CITY OF ALBUQUERQUE

December 3, 2015

RE: **Professional Paint Supply-Storage Building Addition
Grading & Drainage Plan
Engineer's Stamp Date 8/20/2015 (File: ~~E17D029A~~)E17D029A1**

Sheet Title
 GRADING & DRAINAGE PLAN
 Drawn By: B. J. Montoya Checked By:

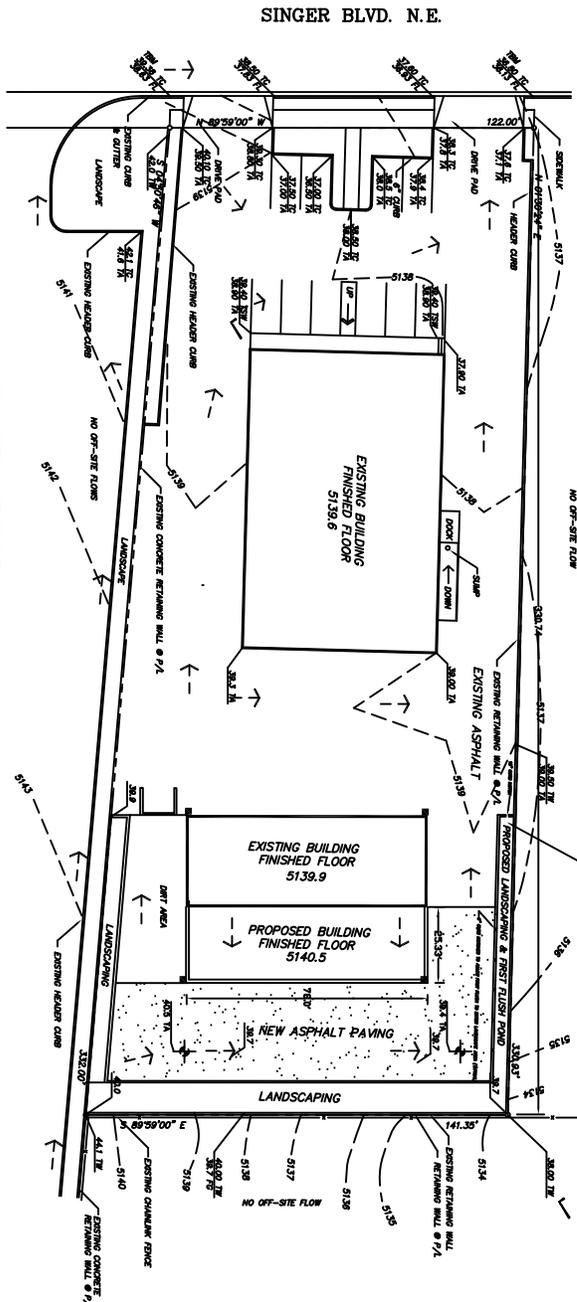
1. The City's "First Flush" requirement must be met for all new construction after May, 2014, <https://www.cabq.gov/planning/documents/SignificantDrainageOrdinanceChanges0414.pdf>. The calculation of first flush volume for this site would only be based on the area that is disturbed with the new construction.
2. Please indicate the limits of new paving on the plan
